## SPR EA1N and EA2 PROJECTS

### DEADLINE 7 - SASES COMMENTS ON APPLICANTS RESPONSES TO ExQs2

Interested Party: SASES

Date: 4 March 2021

**Viewpoint 5 Public Rights of Way, near  
Moor Farm (with National Grid GIS  
Substation)**

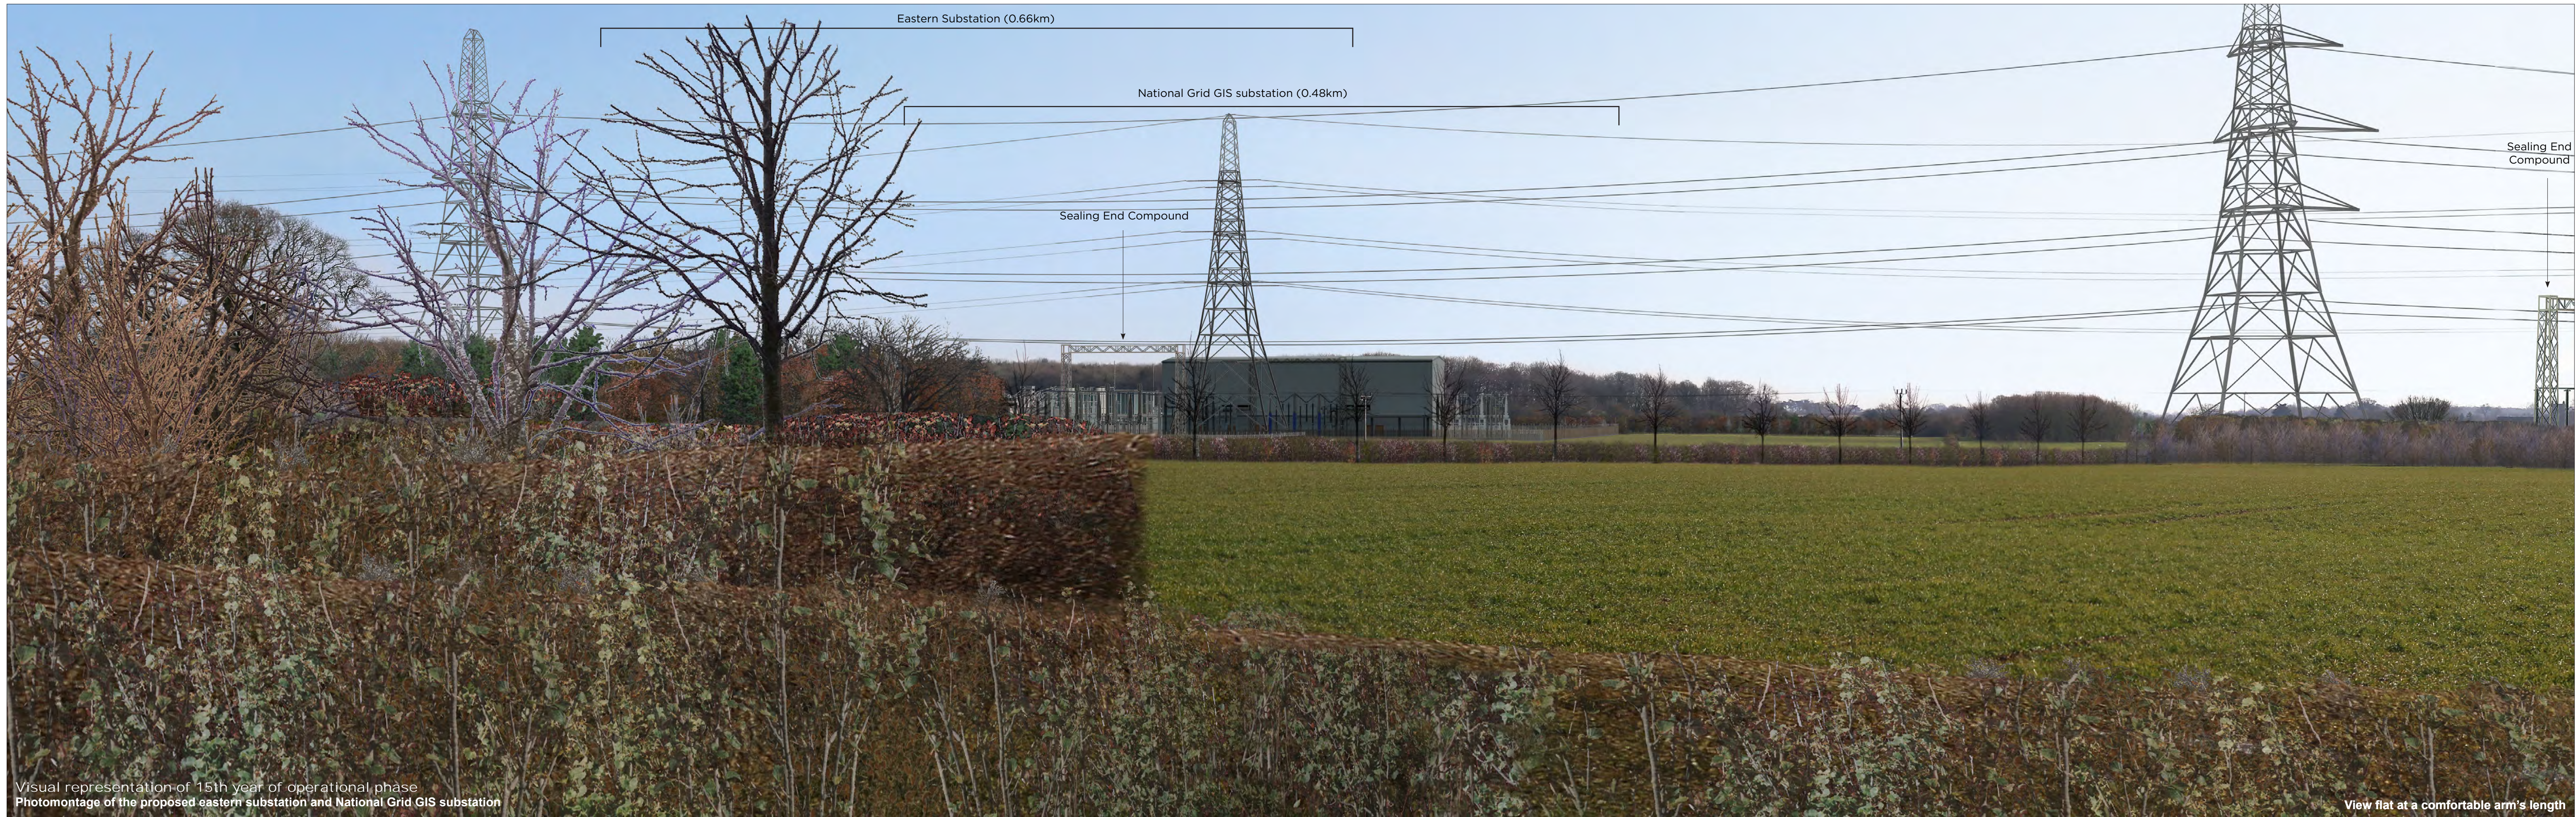
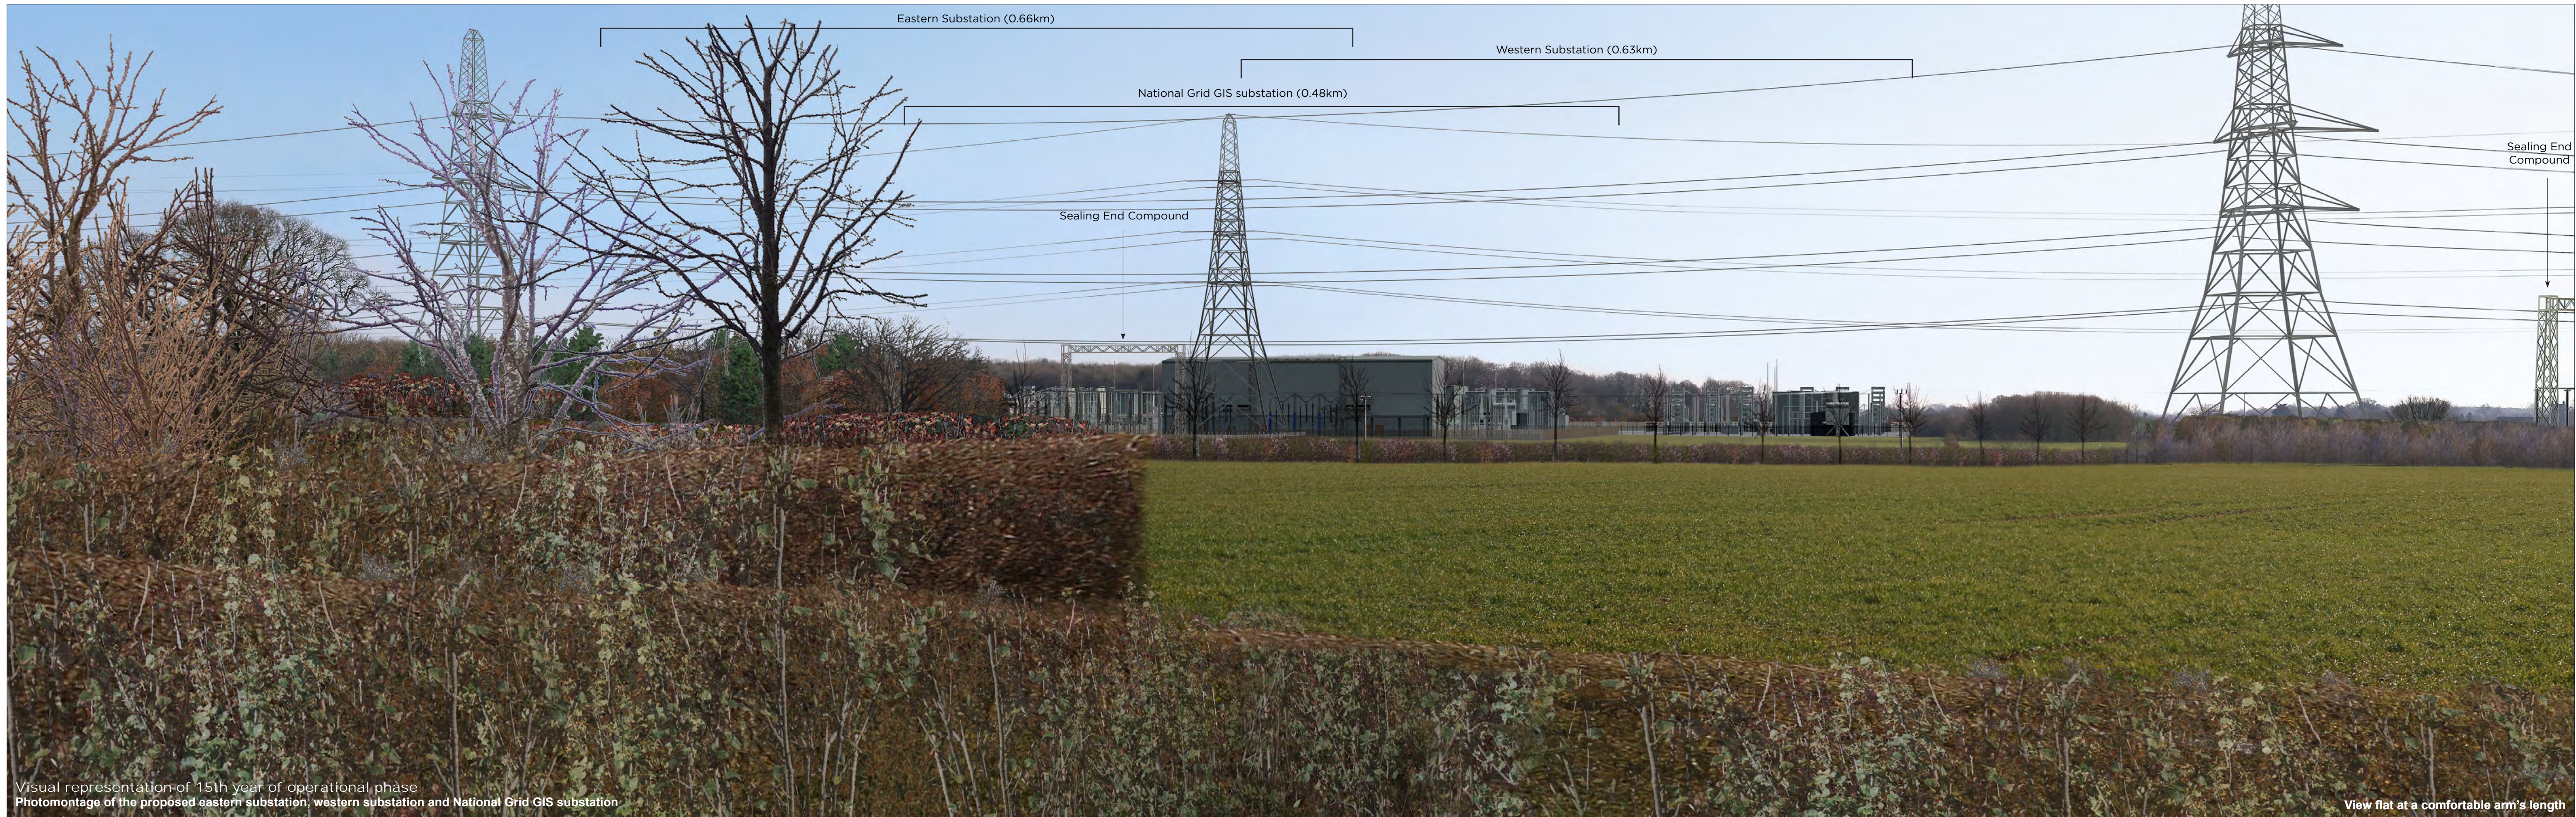
<b>2.8 Historic environment [Dr Richard Hoggett]</b>		
2.8.2	High House Farm	We welcome the observations made by the ExA in their Question 2.8.2 that viewpoints CHVP3 and VP5 do not represent the view southwards from within the curtilage of High House Farm and that long

<p>views are to be appreciated across the open farmland towards the church. Of course, this view is reversed from the church.</p> <p>In their response, the Applicants acknowledge that the curtilage of High House Farm is understood to be cluster of former agricultural buildings, which includes Moor Farm and Friston Barn and their gardens. This represents a much larger and more significant reading of the heritage asset than has previously been acknowledged, with previous assessments focussing on individual buildings rather than the former farm complex as a whole.</p> <p>The submitted visualisations, such as they are, do not support the Applicants' assertion that the construction of the substations and sealing end compounds, the latter being situated between 230m and 275m away, will not sever the connection between High House Farm and the church. We have consistently stated that it will, and this conclusion has been reached by other parties with heritage interests.</p> <p>Furthermore, the Applicants' acceptance of the fact that the proposed mitigation planting adjacent to High House Farm will indeed sever the views of the church is a clear indication that the mitigation scheme in itself will also have a detrimental impact upon heritage assets, in addition to the substations and infrastructure themselves. Again, this has been consistently identified by us and other parties as a material concern, in that the proposed mitigation scheme is at best ineffective and at worst harmful.</p> <p>As has been rehearsed in writing and orally, we do not accept the Applicants' position that the views and long-range connection between High House Farm and the church do not add to the significance of either of these heritage assets. On the contrary, the survival of the survival of the complex interrelationship between the heritage assets to the north of Friston is a strong element of the historic landscape character of the proposed development area.</p> <p>The significant change in landscape character proposed to the south of the High House Farm will have a detrimental impact, the scale of which we consider the Applicants has underestimated in their own assessment.</p>
